SUBJECT: Manant Commercial Center Portion Lot 1 Bk 1
Vidas Subdiv.

RE: GRADING & DRAINAGE PLAN FOR COMMERCIAL CENTER FOR
ELMER SPROUL (H17-D25) RECEIVED MAY 11, 1984.

REF: REVISED GRADING AND DRAINAGE PLAN FOR COMMERCIAL CENTER @ 5000
MENAU NE (H17-D25) RECEIVED JUNE 29, 1984

**DRAINAGE-HYDROLOGY PLAN**  
1" = 20' 0"

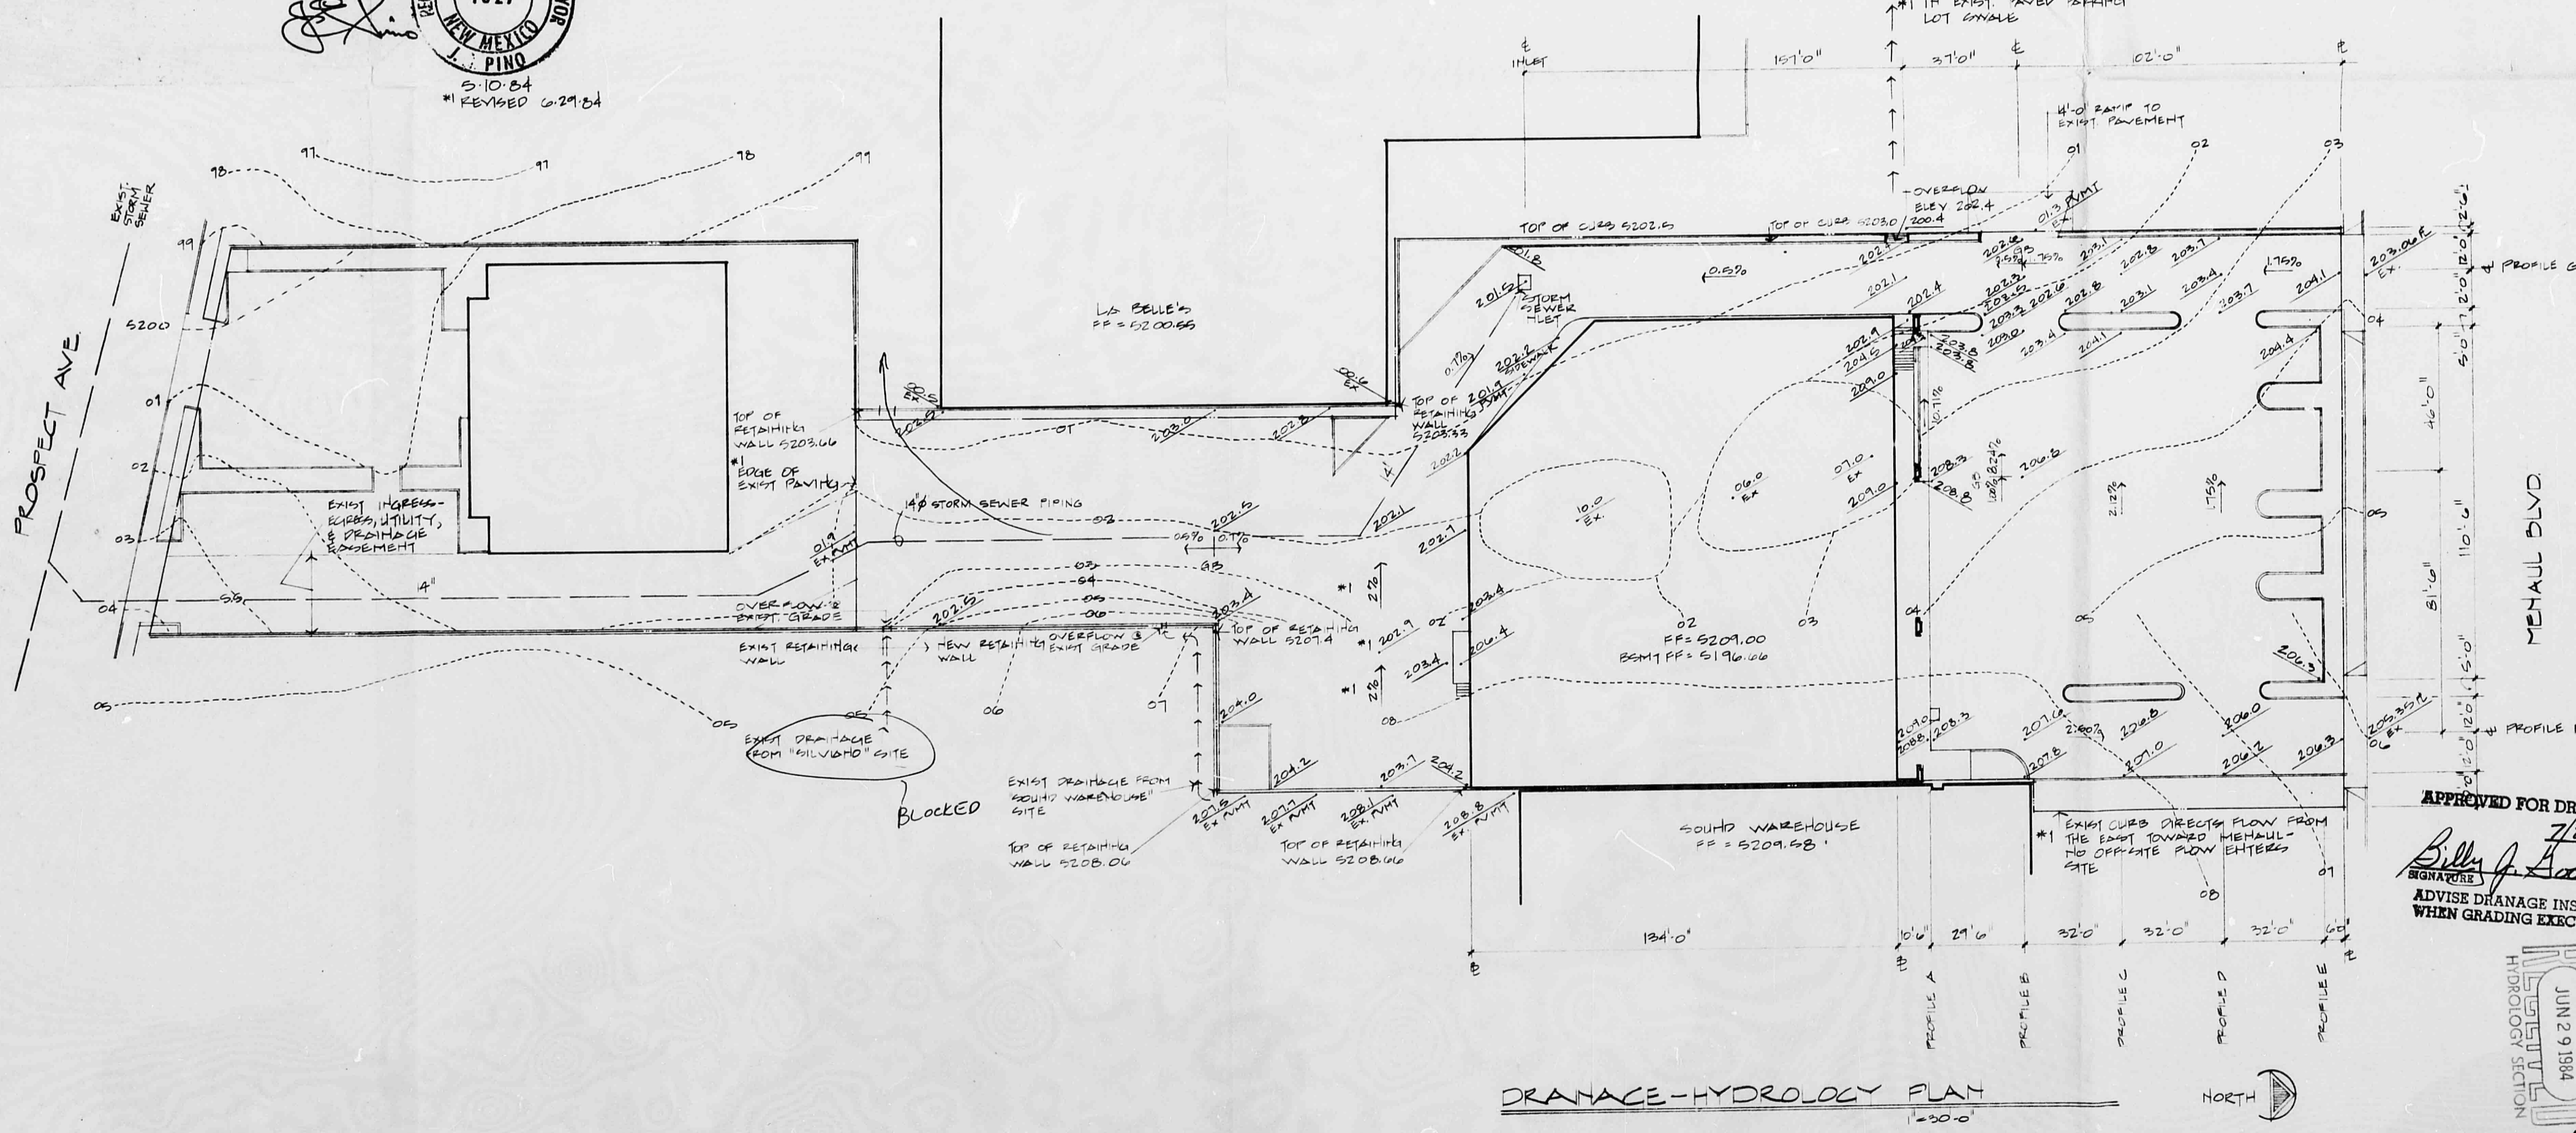
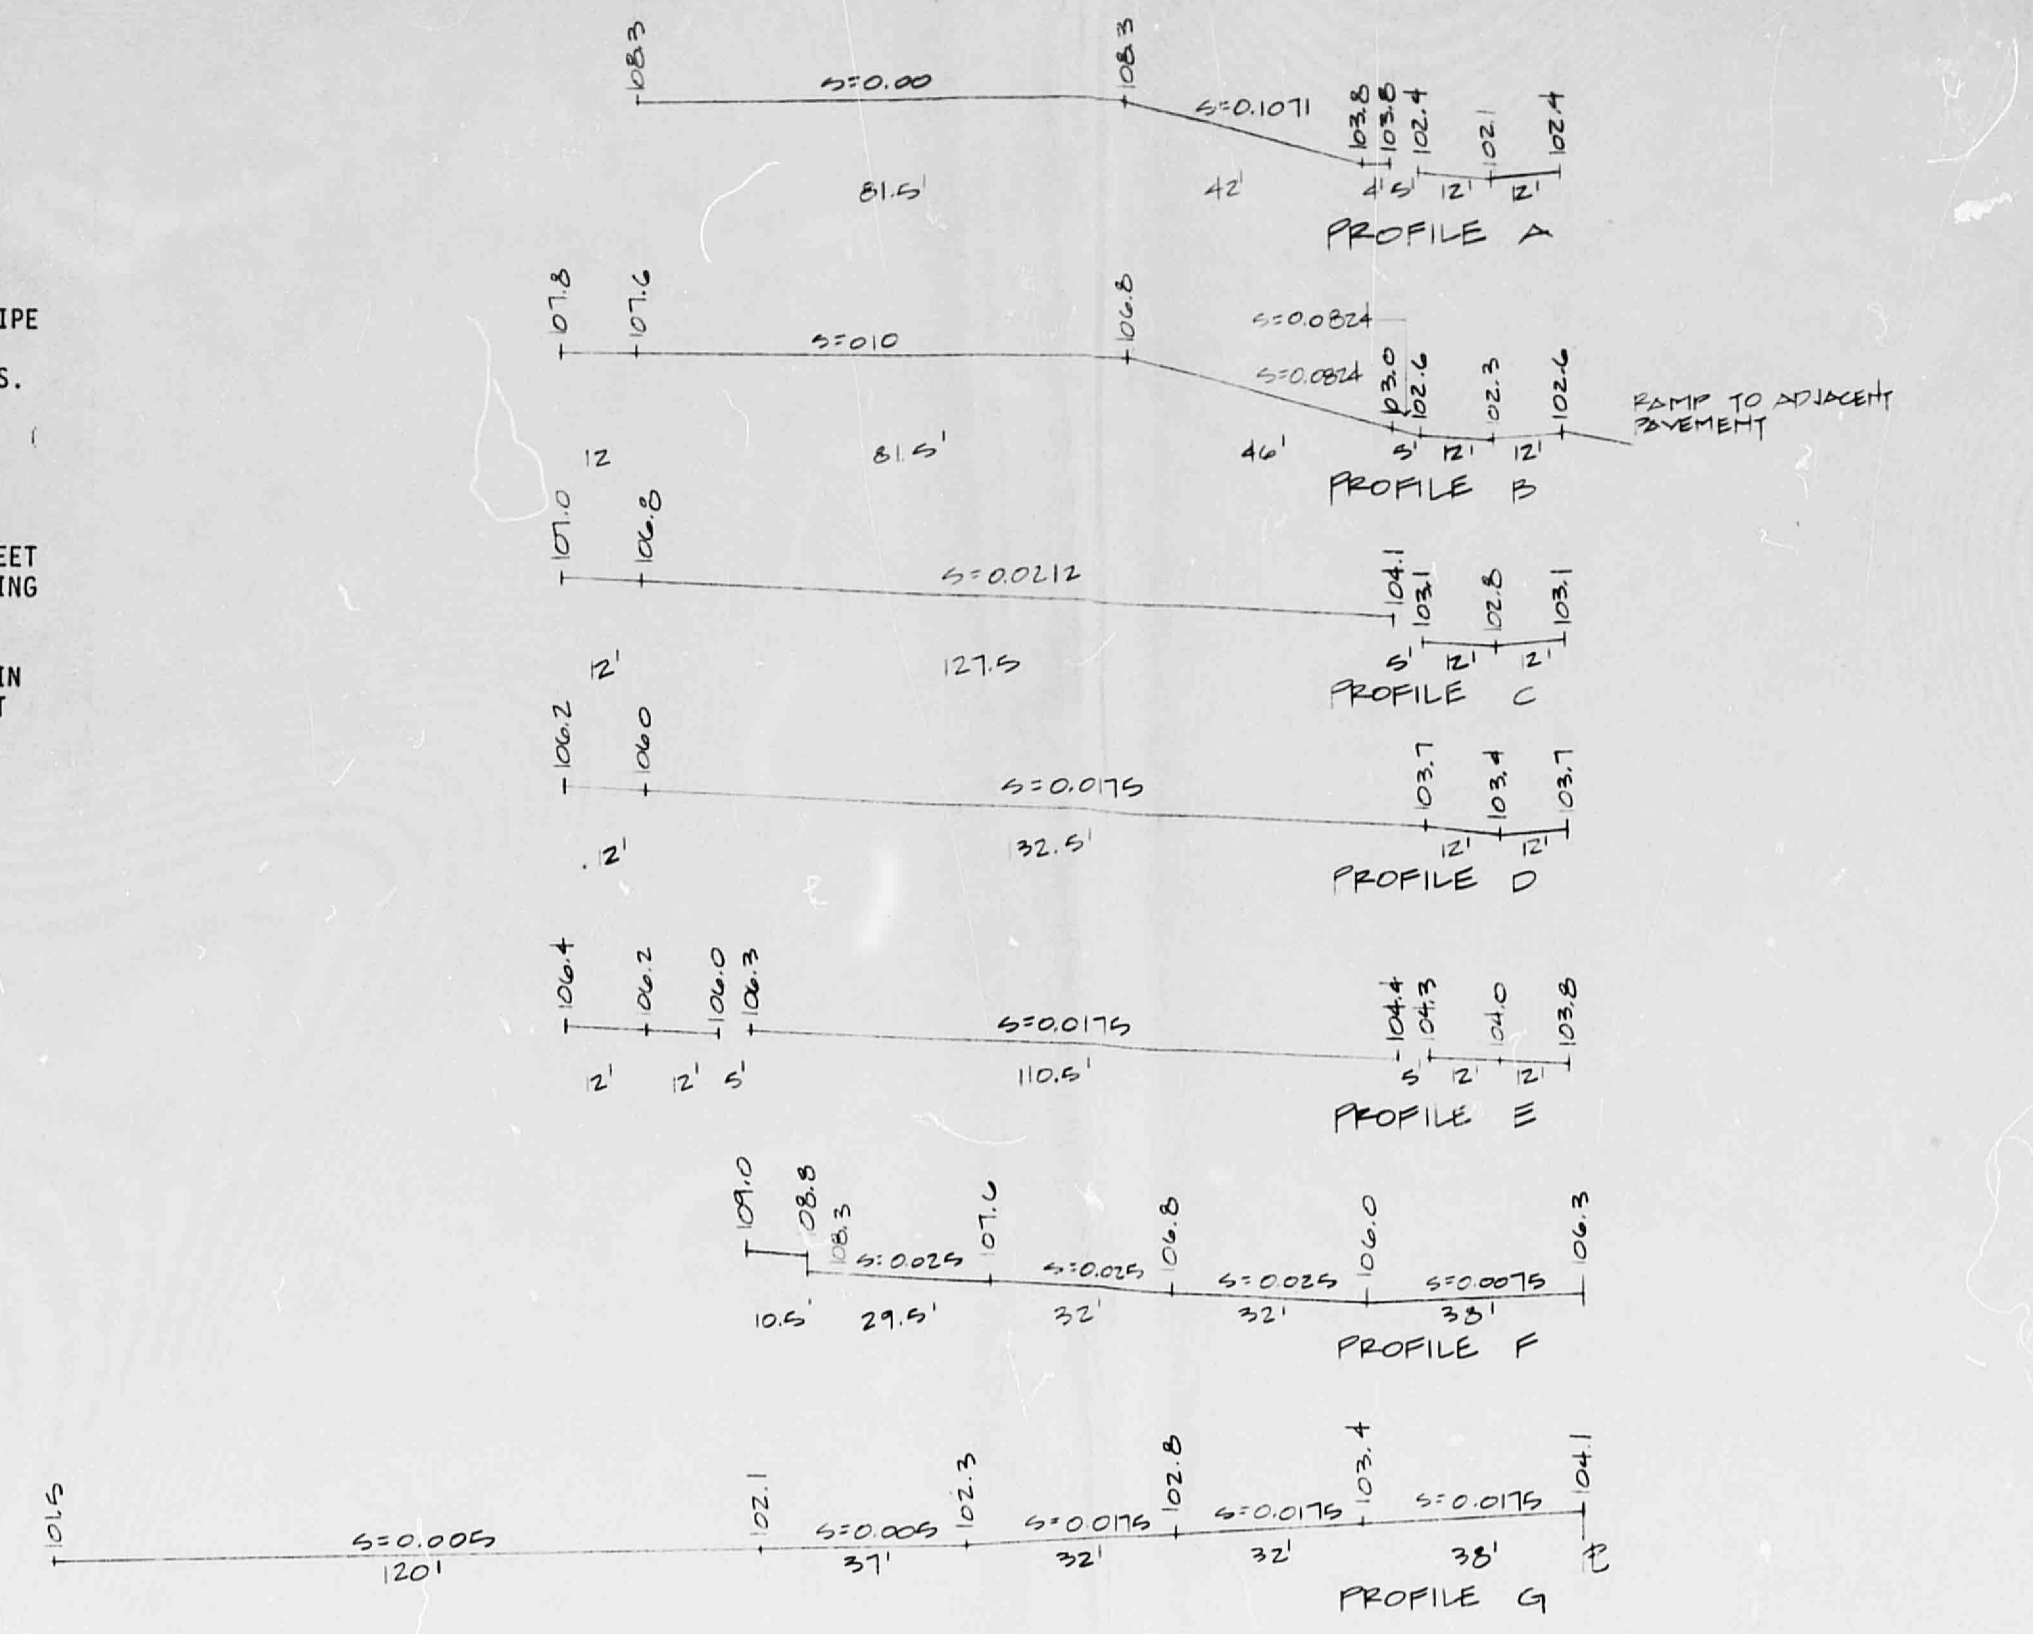
Please refer to the DPM checklist for requirements regarding the plan to be submitted. This plan is currently incomplete for approval.

Also, please provide the hydraulic calculation for the design of the proposed stormsewer system.

The above referenced plan, dated June 29, 1984, is approved.
